From: Bloomer, David <David.Bloomer@lancashire.gov.uk>
Sent: 21 October 2016 09:11
To: Rebecca Halliwell
Cc: LHS Customer Service; planning
Subject: app3/2016/0899 The Lodge , Clitheroe road Whalley

Dave Bloomer
Highways Development Control
Lancashire County Council

Drawing Title
GA PLANS AS PROPOSED

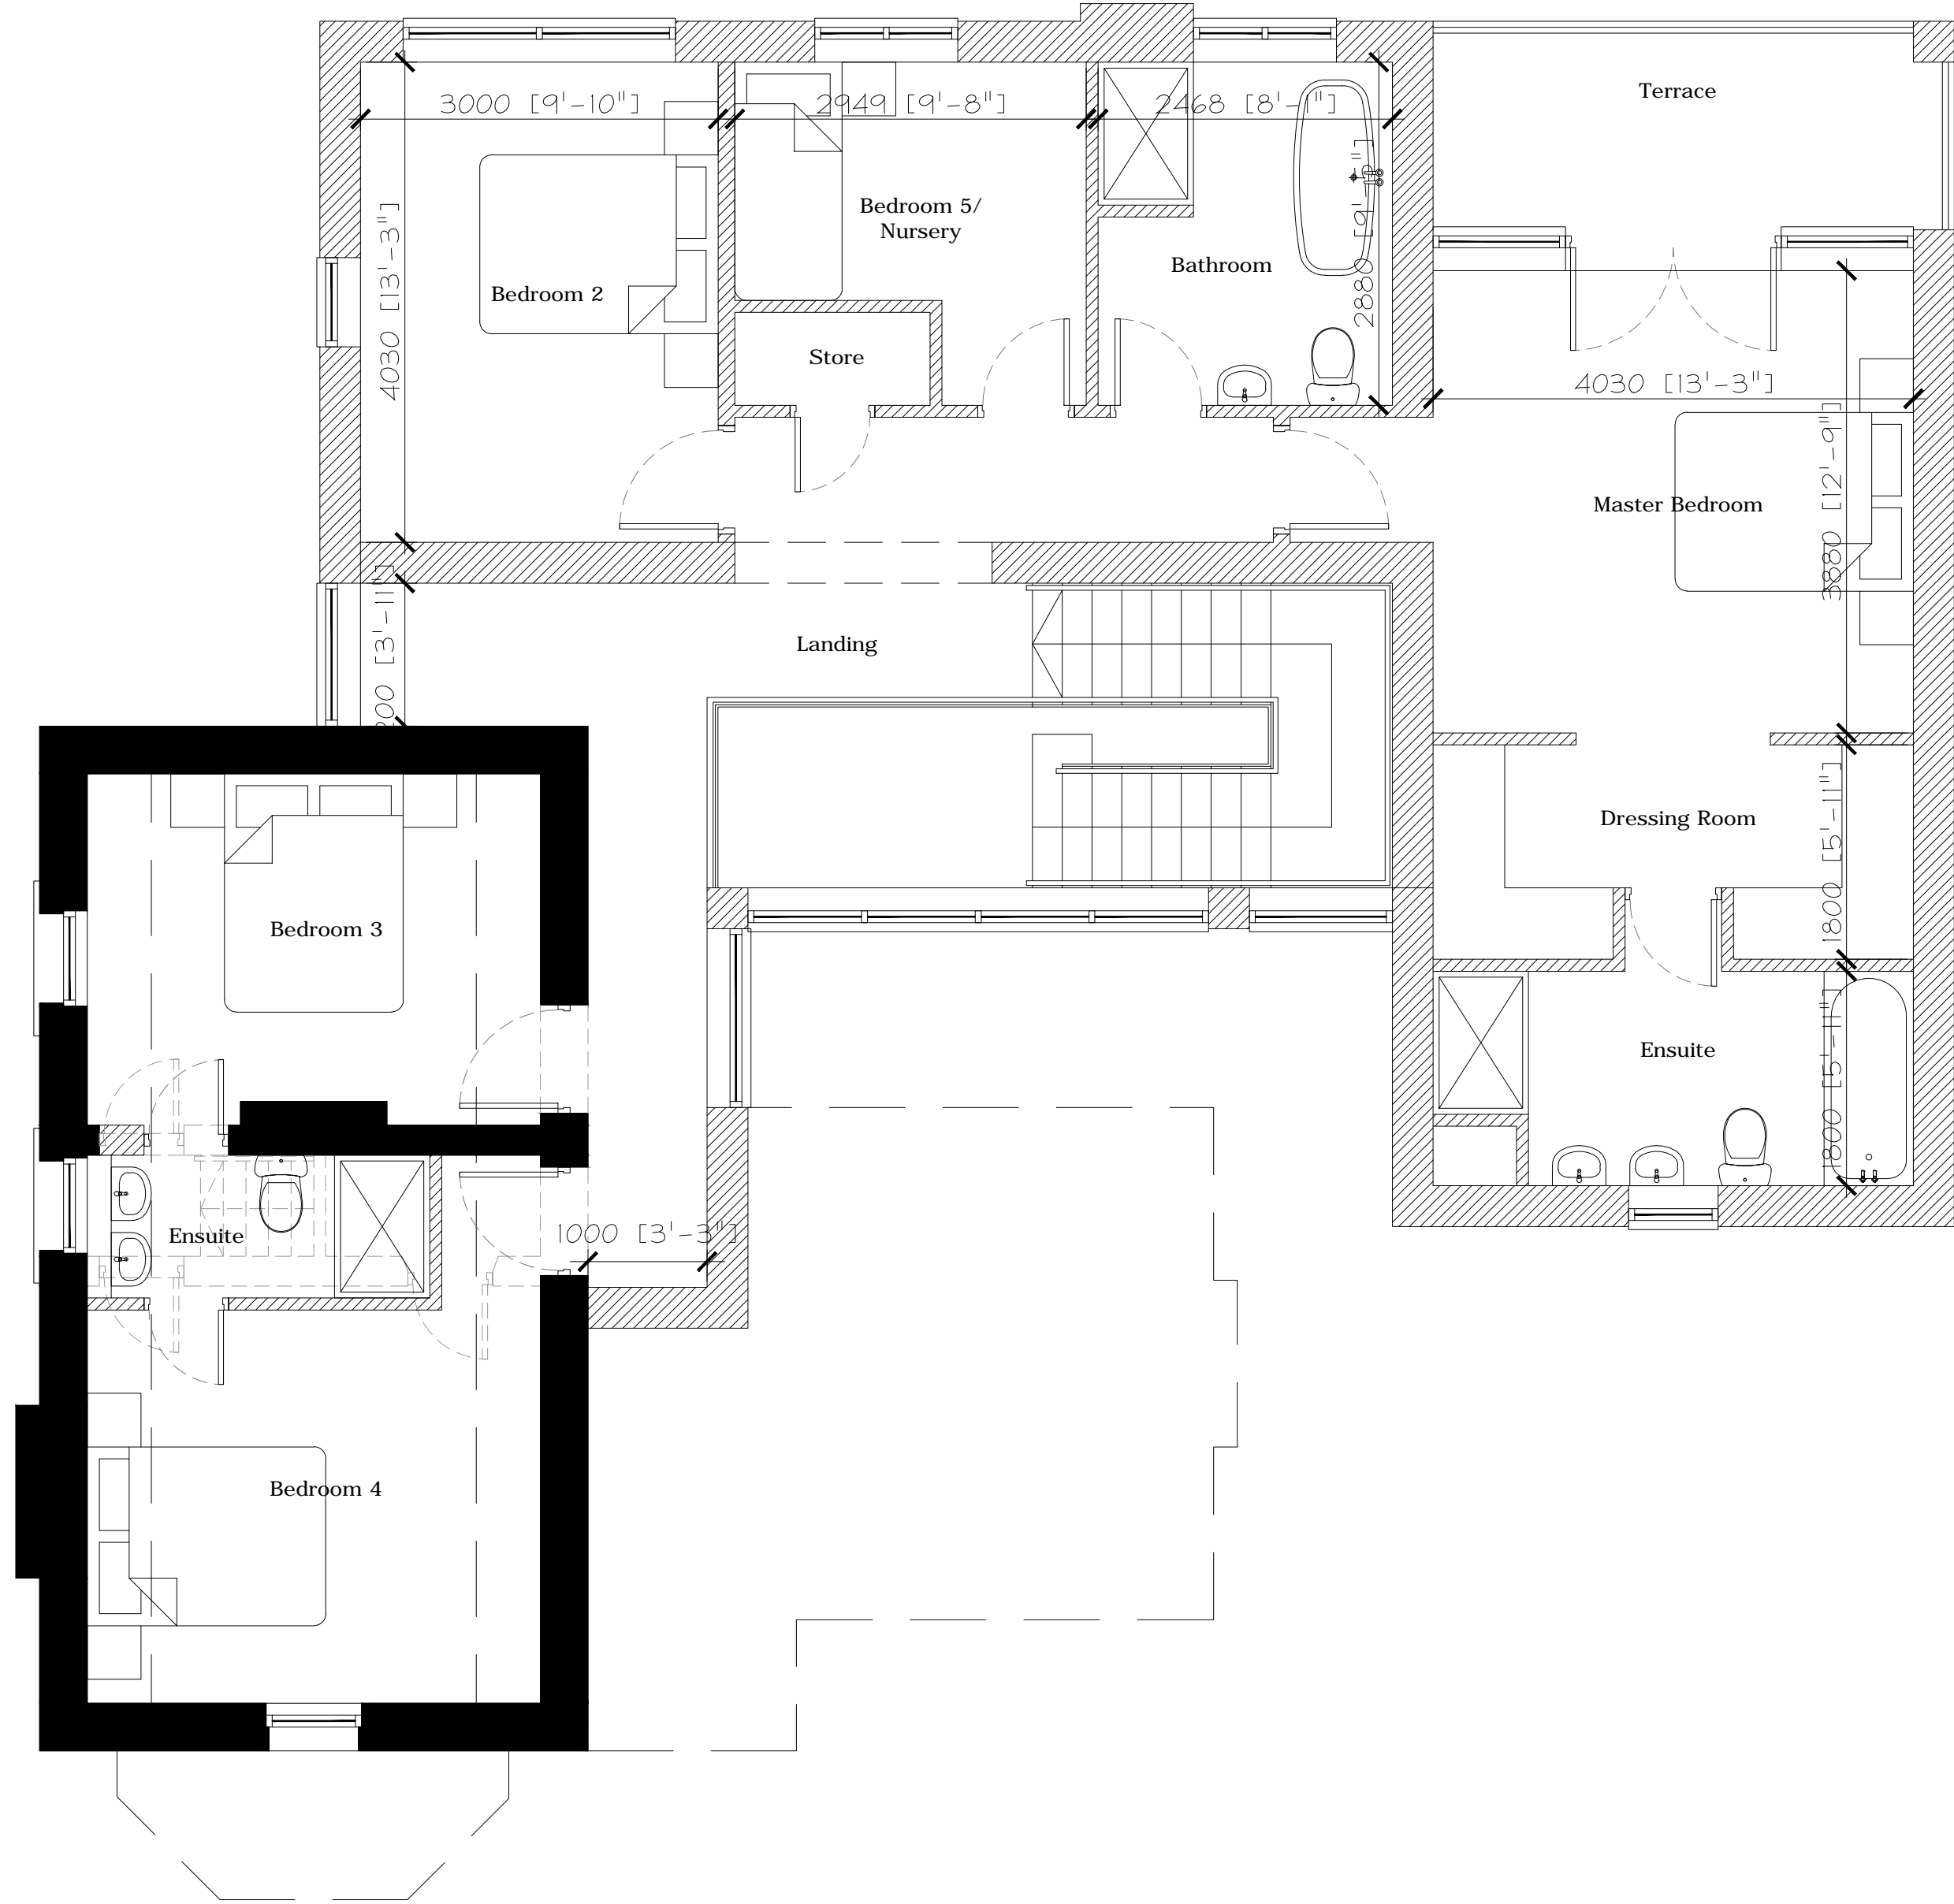
The proposal will increase the number of bedrooms to 5 , however only two parking spaces are shown. The applicant should be providing 3 parking spaces. Also the e2 parking spaces shown lie partially outside the red edge and it is unclear from the documentation provided (no blue edge plan) whether or not the land is under the ownership of the applicant which would call into question the ability to provide the parking shown.

Subject to clarification of the above issue and amended plans showing 3 acceptable parking spaces, I would raise no objection to the proposal on highway grounds.
